STATE OF NORTH CAROLINA
DEPARTMENT OF TRANSPORTATION

Addendum No. 1

RE: Contract ID: C201434
WBS# 37664
Granville County
3 Sections of Secondary Roads.

June 21, 2005 Letting

PROJ. REFERENCE NO.	SHEET NO.	TOTAL SHEETS
37664	3	8
STATE PROJ. NO.	F.A. PROJ. NO.	DESCRIPTION
37664		MA05011R

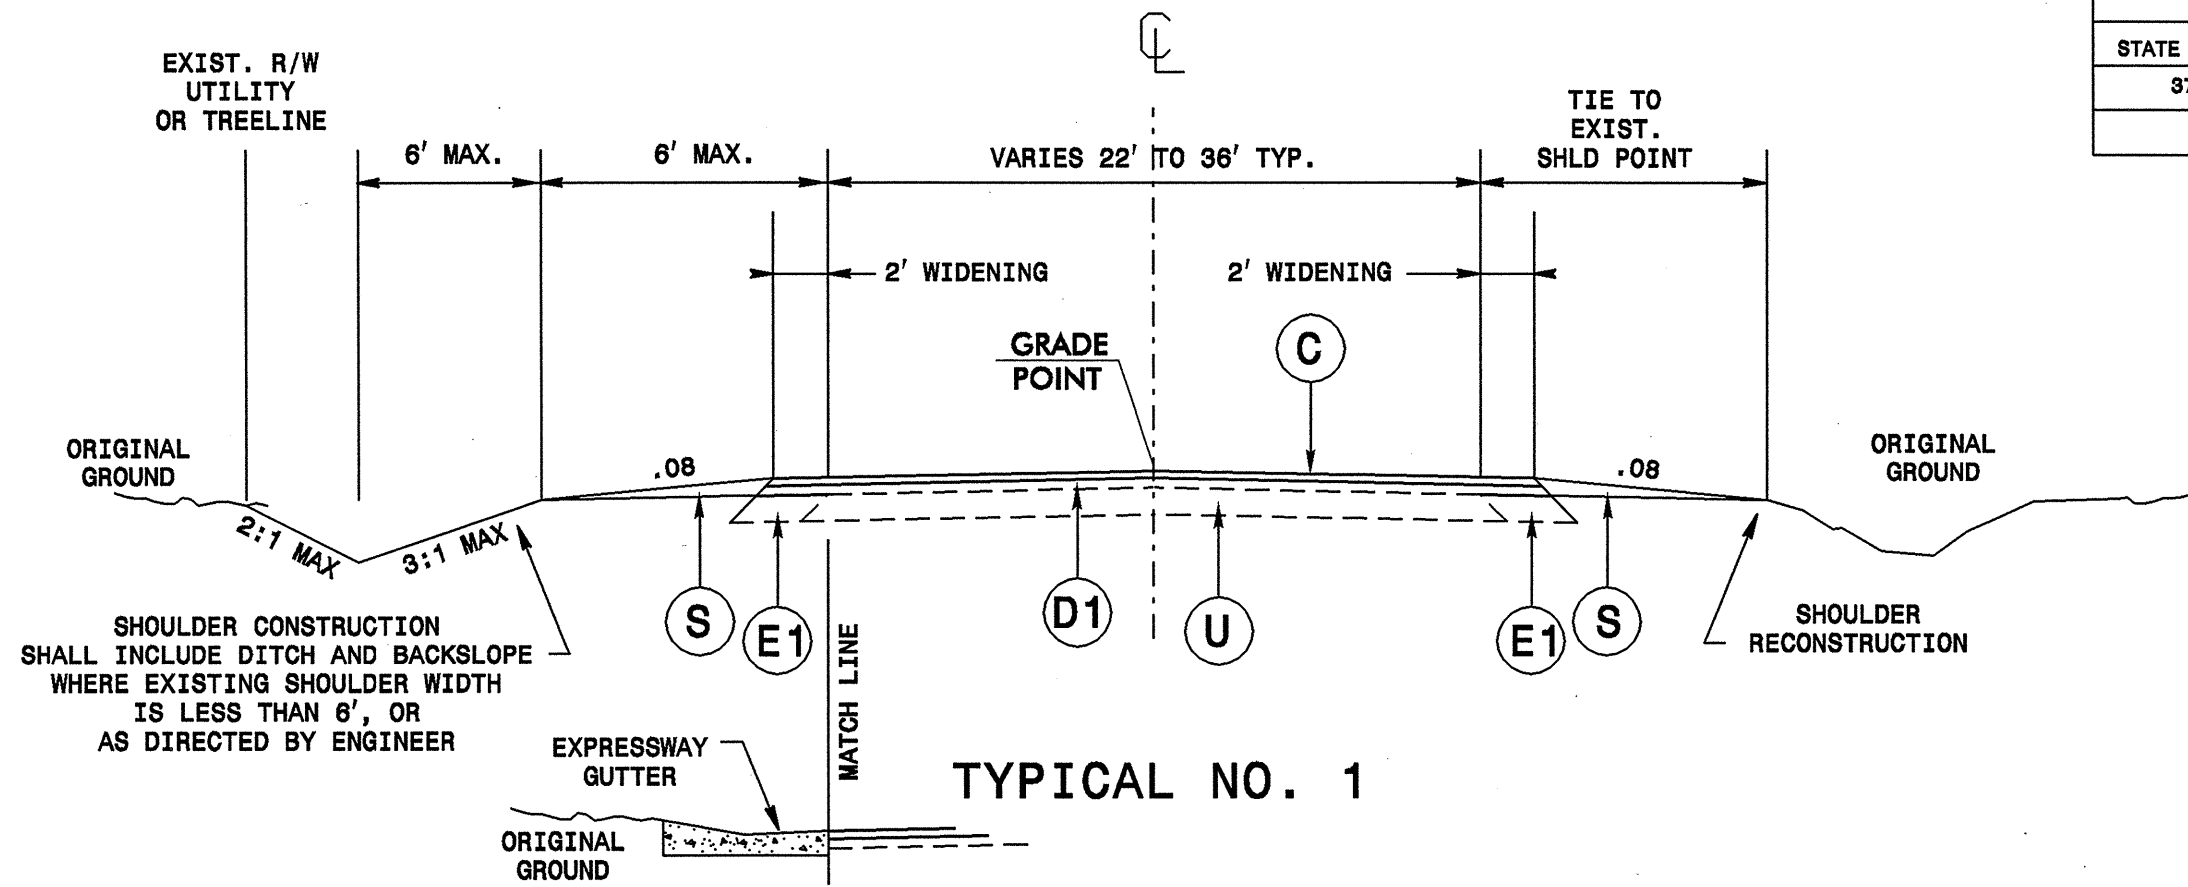
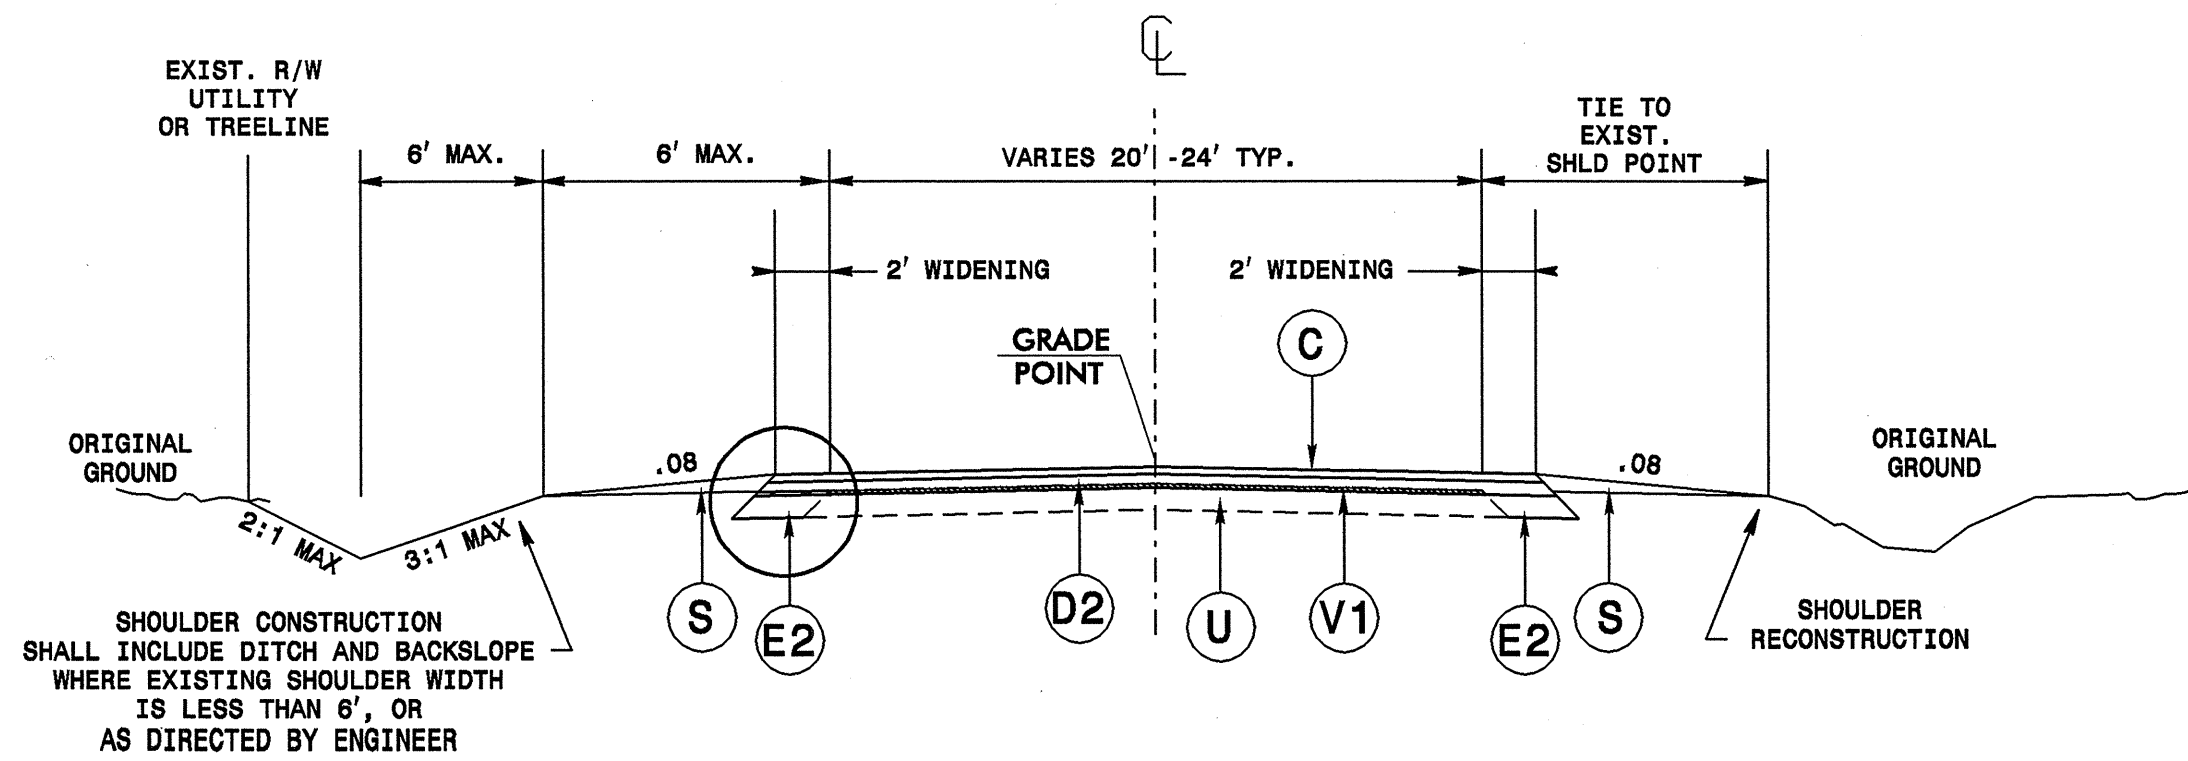
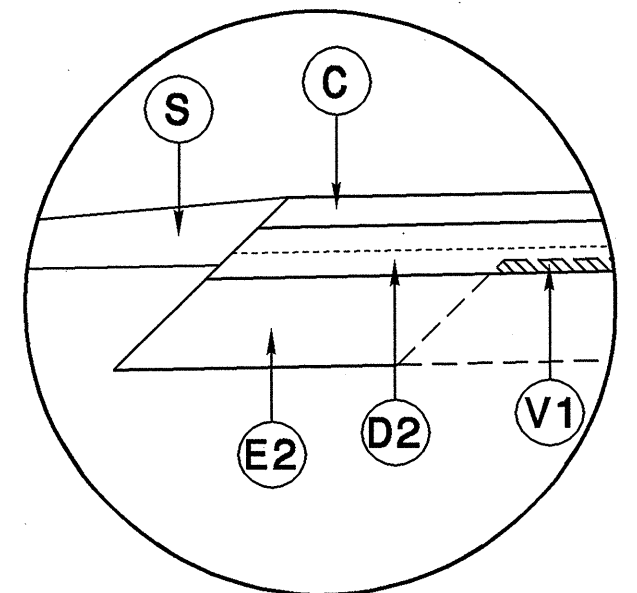
On Sheet No. 3, the typical sections have been revised. Please void Sheet No. 3 in your plans and staple the revised Sheet No. 3 thereto.
